WEST SUSSEX COUNTY COUNCIL CONSULTATION

TO:	Arun District Council FAO:
FROM:	WSCC Highways - Public Rights of Way
DATE:	7 November 2025
LOCATION:	Land off Church Lane Barnham
SUBJECT:	BN/97/25/PL Change of use of land from agricultural use to residential use, creating 4 No permanent private gypsy plots with associated parking, landscaping and facilities. This application affects a Public Right of Way, may affect the setting of a listed building, affects the character and appearance of the Church Lane, Barnham Conservation Area and is in CIL Zone 3 (Zero Rated) as other development.
DATE OF SITE VISIT:	7 November 2025
RELEVANT PUBLIC RIGHTS OF WAY NUMBER(S):	Public Footpath 323
RECOMMENDATION:	Objection
S106 CONTRIBUTION TOTAL:	n/a

PROJECT
Proposed Change of Use to 4no. Gypsy/Traveller
Plots on Land off Church Lane, Barnham
CLIENT
Mr A Brazil
STATUS
DRAFT
DRAWING
PROPOSED SITE PLAN

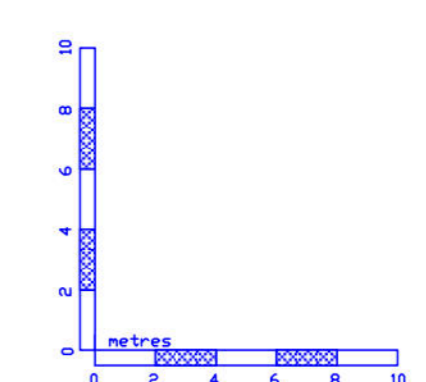
Since the previous planning application, I note that the applicant no recognises the need to formally divert the public right of way, likely under Town & Country Planning Act 1990 s257, onto what has long been the used route. I have undertaken a site visit following the receipt of reports about the path. I found the path to be fenced in and closely planted with laurel on the far side of each fence. The available width was approximately 1.4m, significantly reduced by a tree within the path and also at the entry point from Church Lane.

When fencing in a path, we require a minimum 2m available width to off-set the inevitable vegetation overgrowth and increased wear of the surface with users confined to a narrow path. The choice of laurel, which is a fast growing, evergreen shrub, will make this path increasingly uninviting, with it being dark and overgrown. The vegetation will grow tall and dense reducing the light and airflow to the path, adversely affecting the surface, which I already found to be muddy and slippery.

I need to object on the basis that this work was undertaken with no reference to ourselves as to what is required and I must ask that the Planning Authority insist that work is done to provide a greater width for the public footpath.

In addition, the plans present an opportunity to resolve an existing issue on the path where a wall and a gate post have created a narrow squeeze gap that is not acceptable

in terms of accessibility. The applicant is requested to contact West Sussex Rights of Way Team [REDACTED] to determine what is needed.
